14. APPENDIX H - HYDROCK RESPONSE TO CHECK AND DISCREPANCIES

From: Jason Magee
Sent: 20 October 2021 17:46
To: Gareth Jones
Cc: Jason Walker
Subject: RE: [Hydrock: 13319_1-SBNO] C-13319 - Saltbox, Bognor Regis - Condition 15
Attachments: Level change summary and gradients_GJ_20.10.2021.xlsx; SAL-HYD-PH1-ZZ-DR-C-7021_C09.pdf; SAL-HYD-PH1-ZZ-DR-C-7022_C10.pdf; SAL-HYD-PH2-ZZ-DR-C-7010_C07.pdf; SAL-HYD-PH2-ZZ-DR-C-7011_C05.pdf; SAL-HYD-PH2-ZZ-DR-C-7012_C04.pdf; SAL-HYD-PH1-ZZ-DR-C-7010_C09.pdf; SAL-HYD-PH1-ZZ-DR-C-7011_C06.pdf; SAL-HYD-PH1-ZZ-DR-C-7020_C08.pdf

I have reviewed as-built information from ADBLY and compared it to the Hydrock as-built drawings. There are a number of discrepancies that I have outlined on the attached schedule. Could see you please revise drawings accordingly. This includes the following: -

DRAWING NO. (PROJECT CODE-ORIGINATOR-ZONE-LEVEL-TYPE-ROLE-NUMBER)	REVISION
SAL-HYD-PH1-ZZ-DR-C-7020	C08

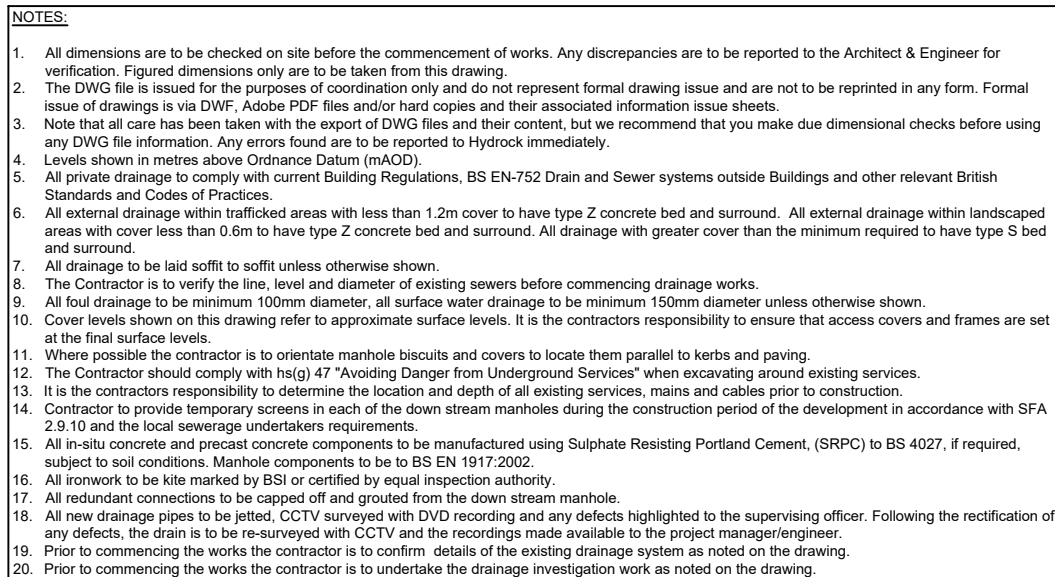
8. FC 501 ADBLY manhole reference incorrect, differs from Hydrock as built drawing

Noted.

SAL-HYD-PH1-ZZ-DR-C-7010

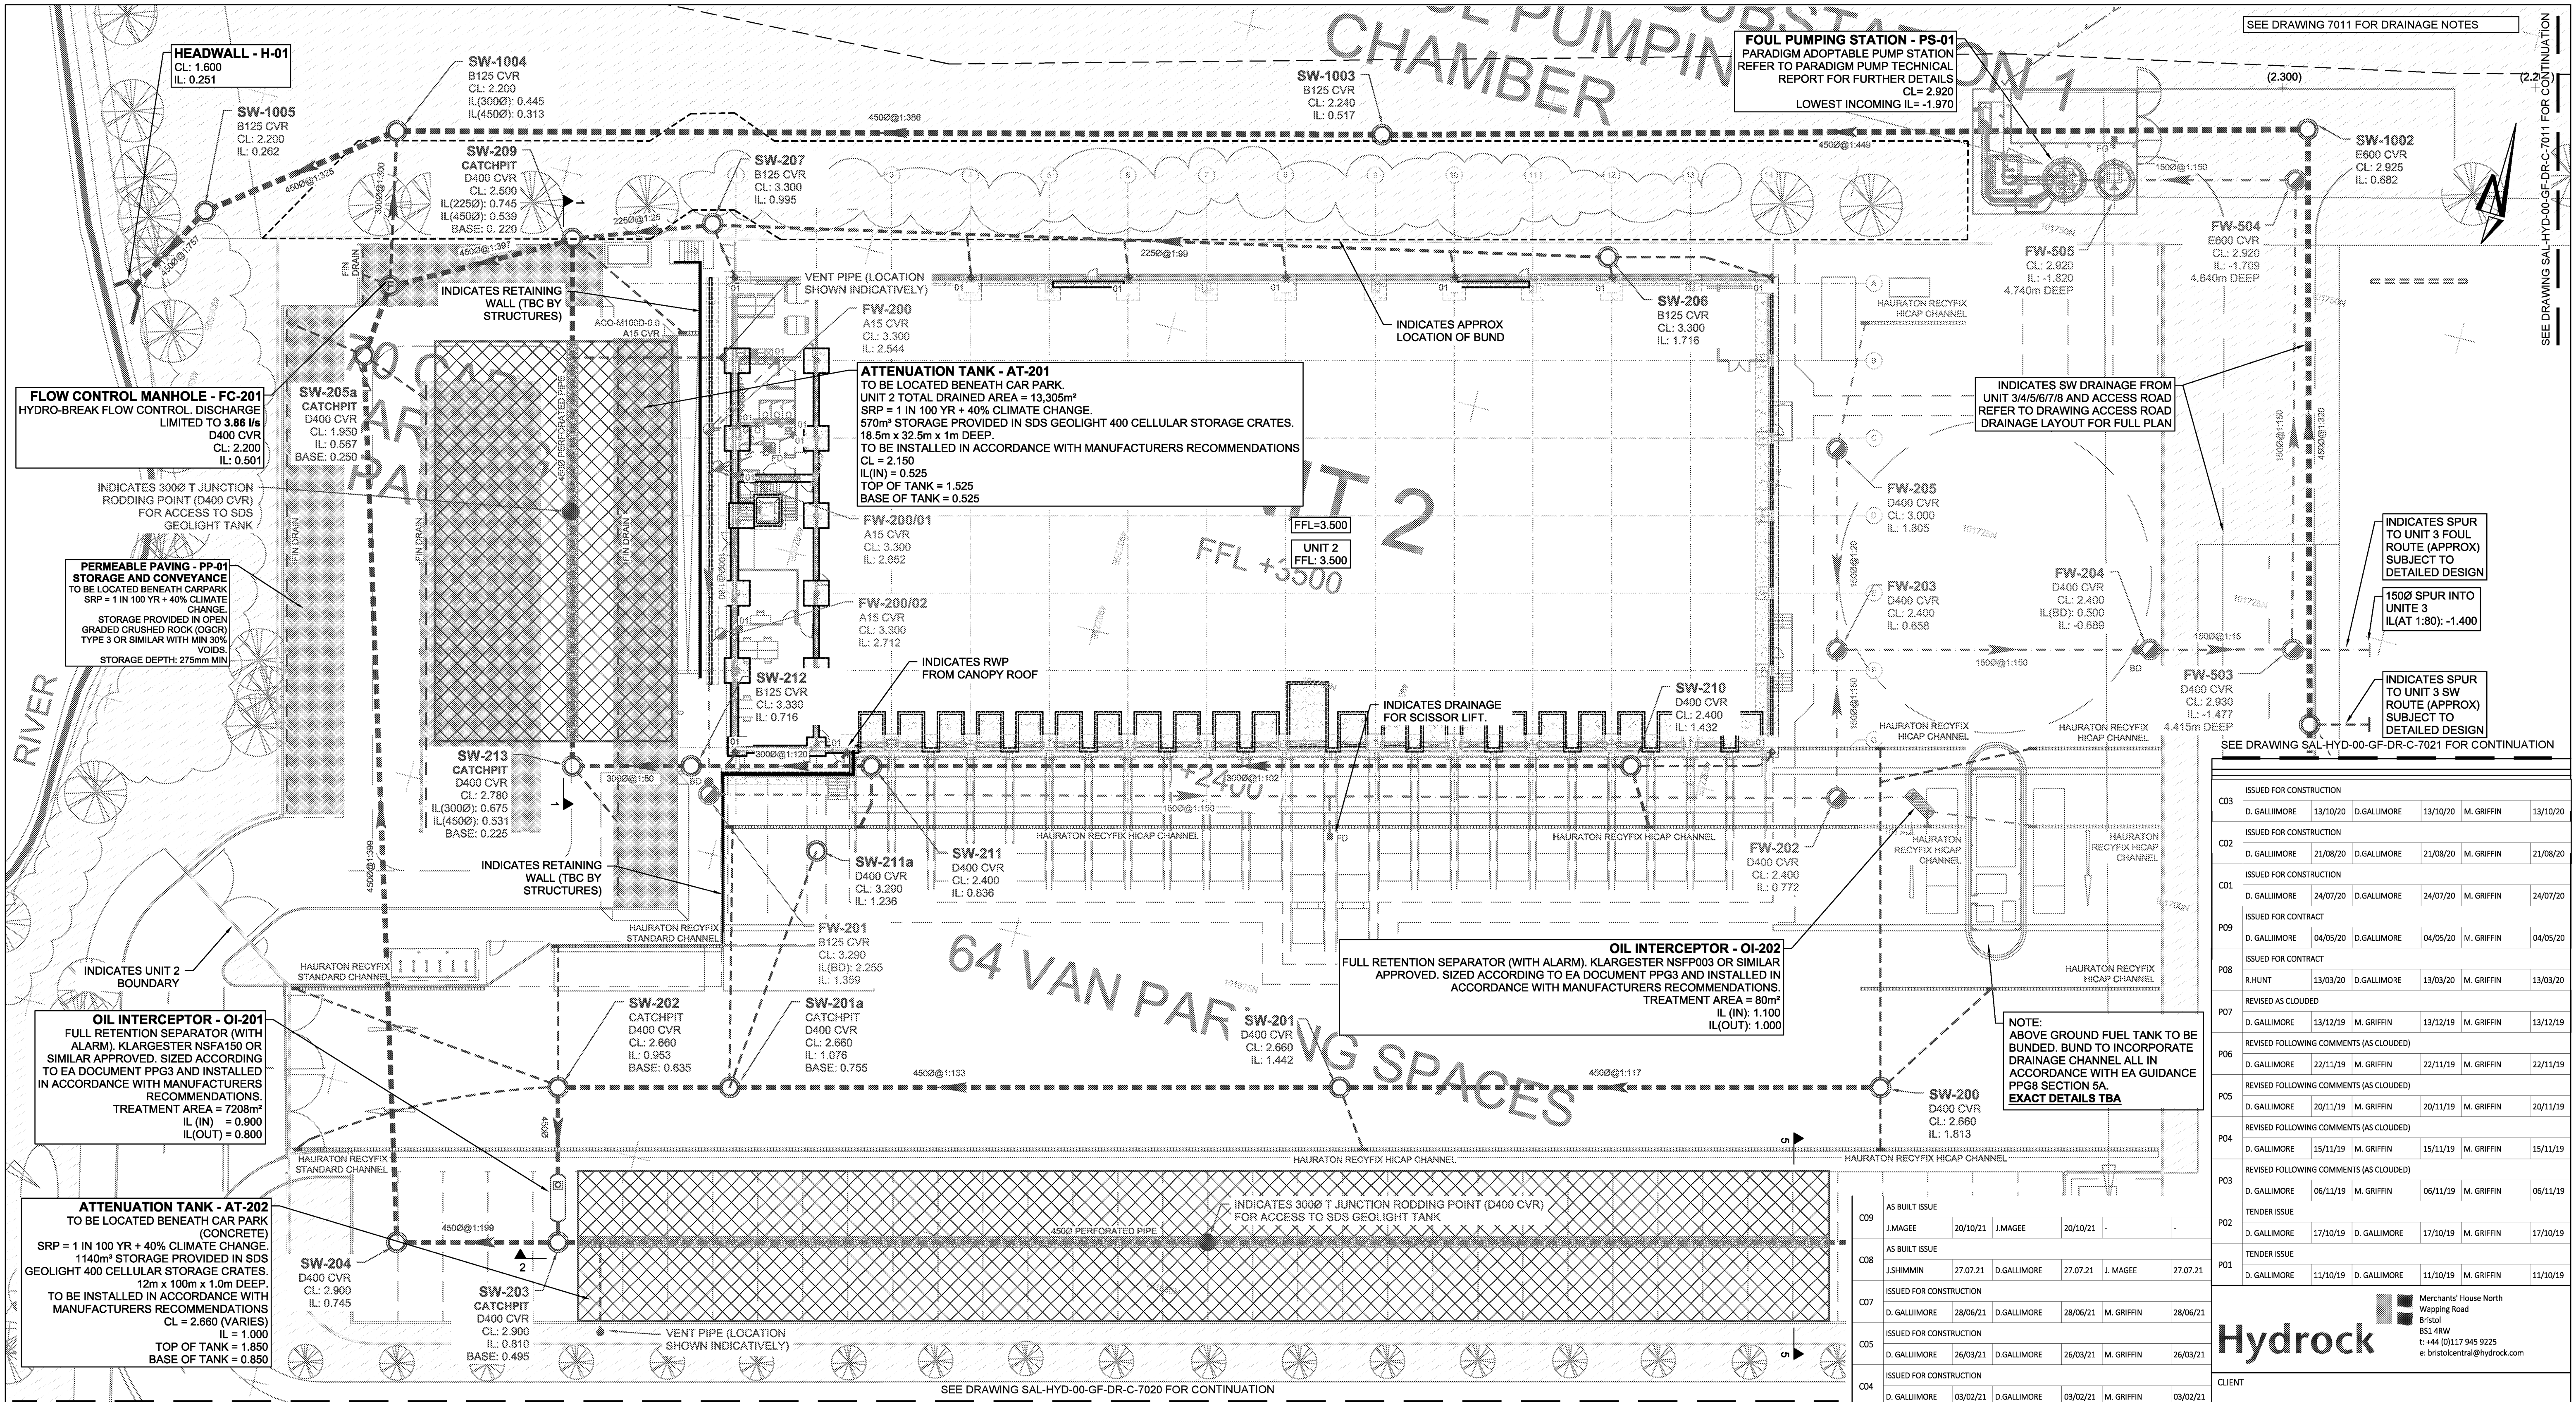
3. SW 211a not shown on Hydrock Drawing.

Added to drawing 7010.
